**Consultation Response from KC,
Highways Development Management****2025/91185 building at, Back Chapel Lane, Moldgreen, Huddersfield, HD5 9BG****Demolition of redundant engineering building and erection of student accommodation block****Date Responded: 12/11/2025****Responding Officer: CNB****Responding Ref: K5-10SE/7**

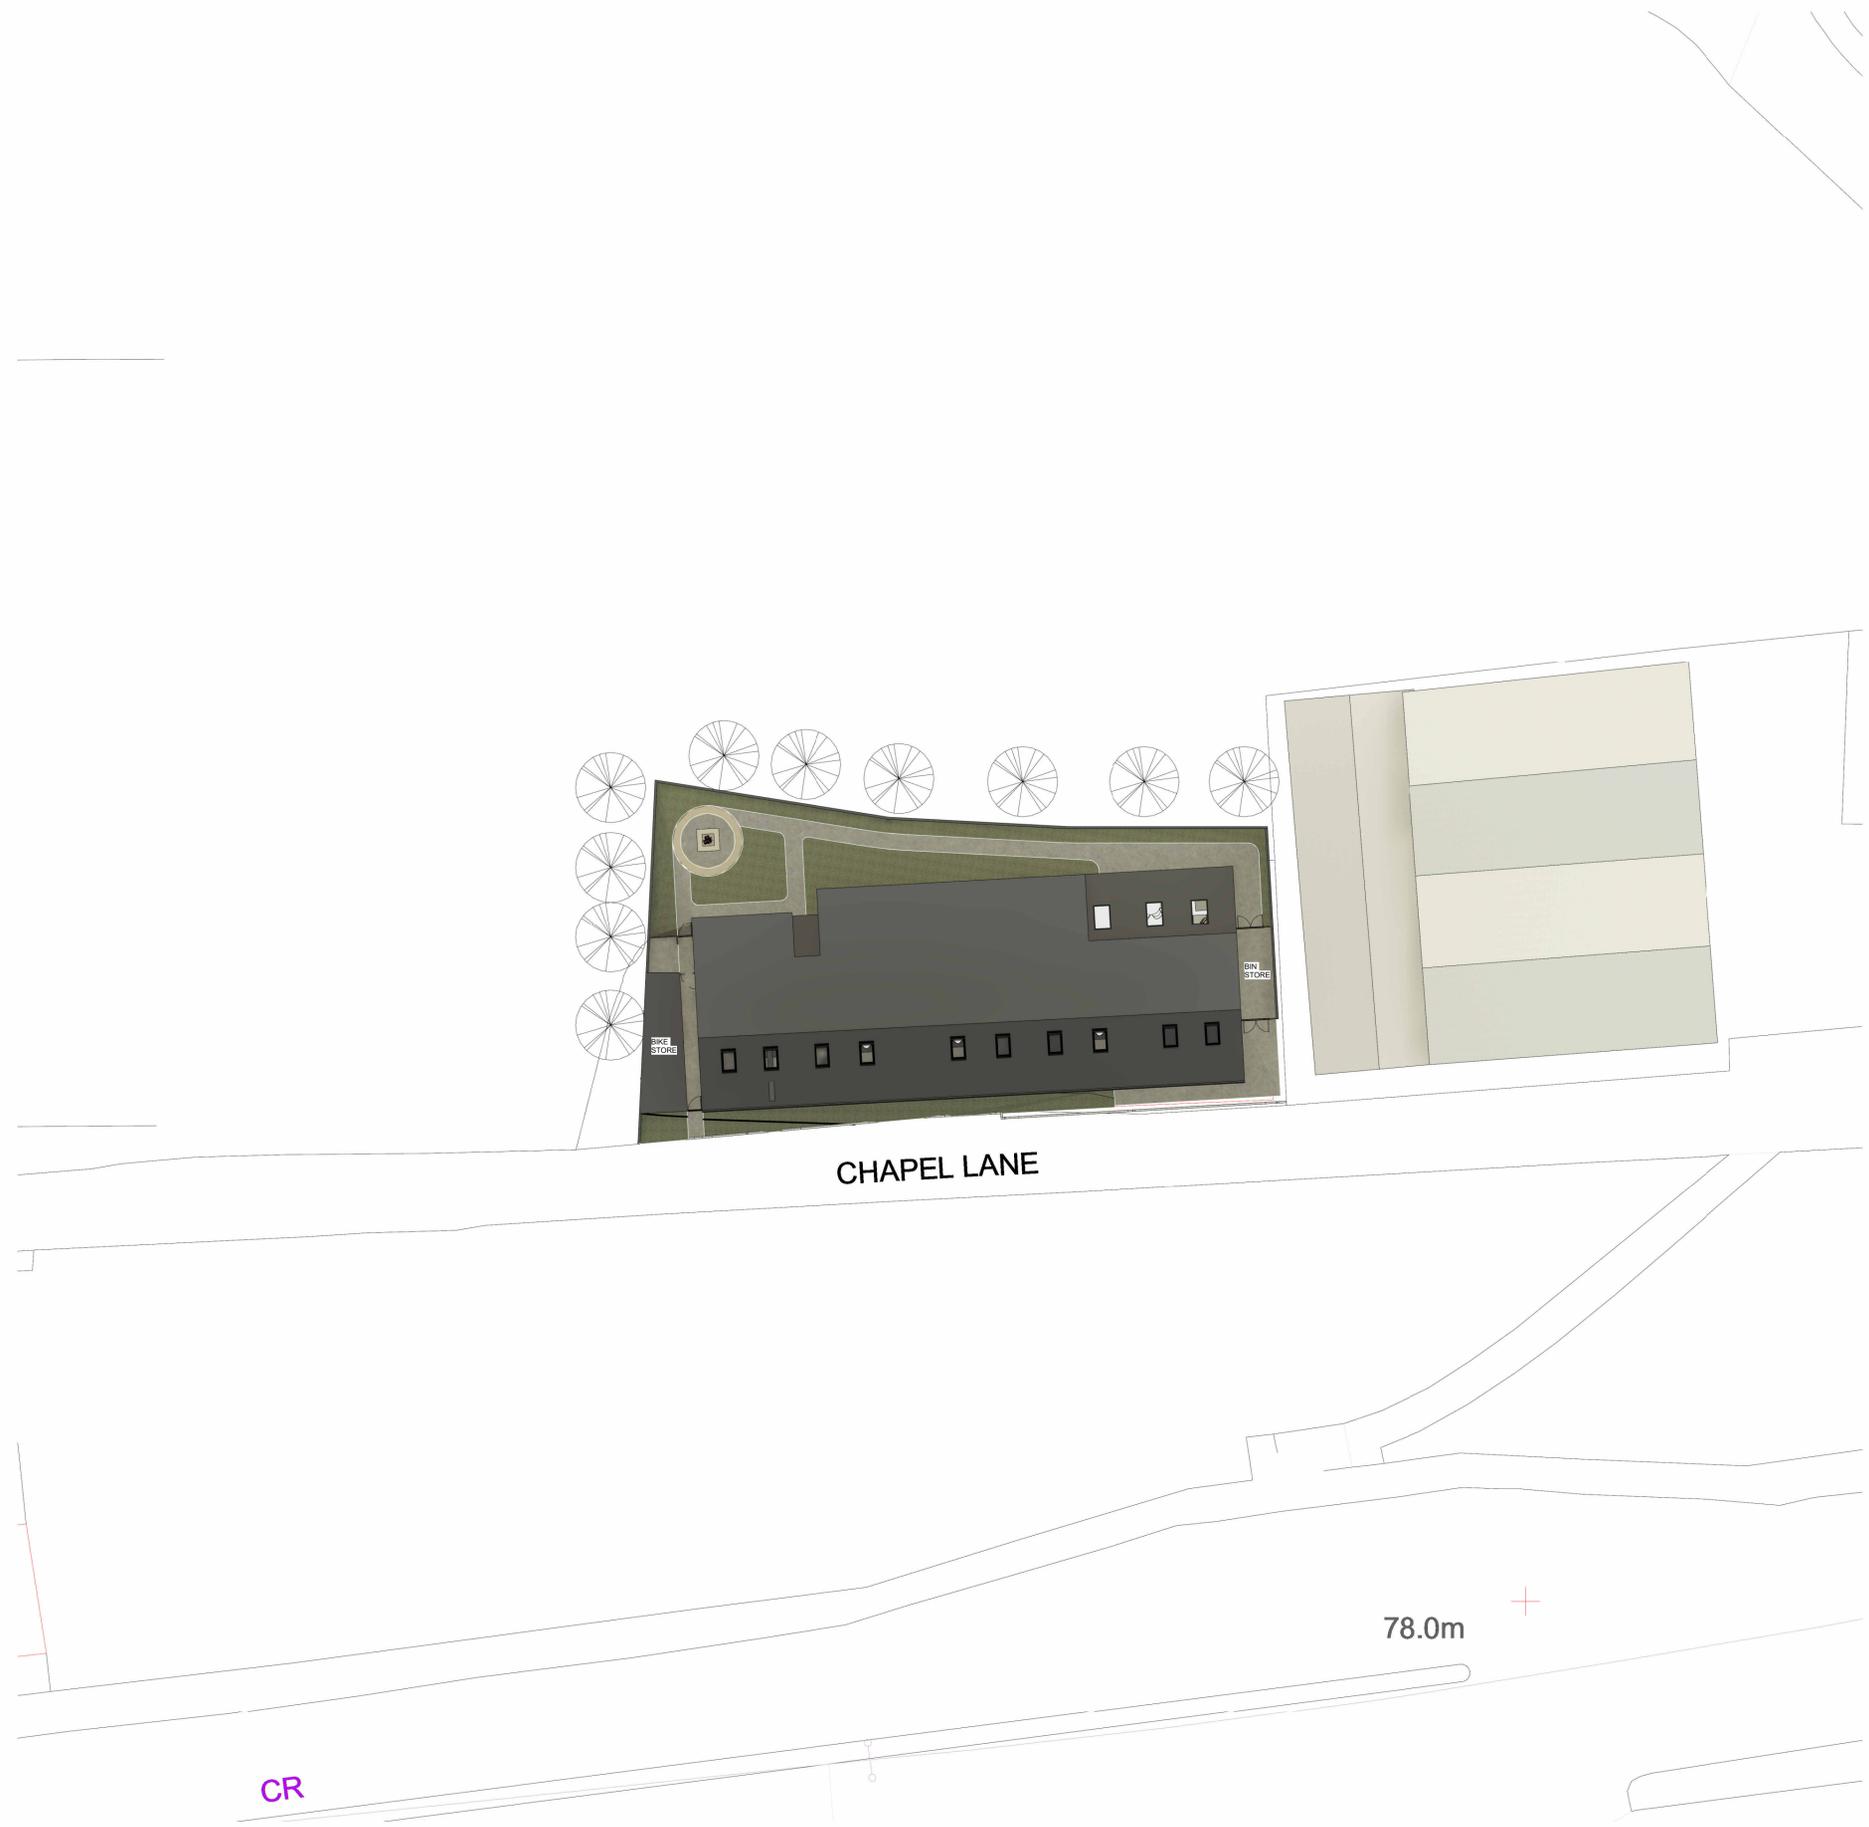
The pre-app consultation response requested that the applicant considers providing a suitable footway along the frontage of the site to allow pedestrians a level of protection as the exit or enter the premises and this is clearly shown on drawing No 2917 (100)05 Rev B and is acceptable.

It was requested that car parking spaces for a minimum of two cars were provided for drop-off and pick-up at the start and end of term times and these have been provided. These can be used for staff maintenance and servicing during the general operation of the building, however for the drop-off and pick-up times we would like to see a parking management plan that allocates a pre-booked timeslot to drivers so that vehicular arrivals and departures are limited and controlled, this should be conditioned.

Cycle parking is indicated on drawing as being covered and secure and suitable for 36 cycles, this is acceptable. Details of the type and style of cycle stand or locker should be provided, and this should be conditioned. This should be maintained for the full lifetime of the development.

For waste storage details we would request that you consult with the Kirklees Waste Strategy team in order to obtain details of the required number and sizes of waste and recycling bins. A bin store is indicated to the eastern end of the building as shown on drawing No 2917 (100)05 Rev B with a bin collection presentation point indicated adjacent to Chapel Lane, with a dropped kerb to assist waste collection. This is suitable for a highways perspective, however we would like to see a servicing and waste management plan providing prior to first occupation that provides details of how servicing and waste collection will be carried out, including ways to avoid on-street parking that may cause obstruction on Chapel Street, the responsibilities for putting the bins out for collection and returning them to the bin store afterwards to avoid them from obstructing the footway to the front of the proposed building or the highway for road safety reasons.

The development shall not be occupied until a footway as shown on plan no. 2917 (100)05 Rev B, in accordance with details which have been submitted to and approved in writing by the Local Planning Authority. The footway so approved shall thereafter be retained.
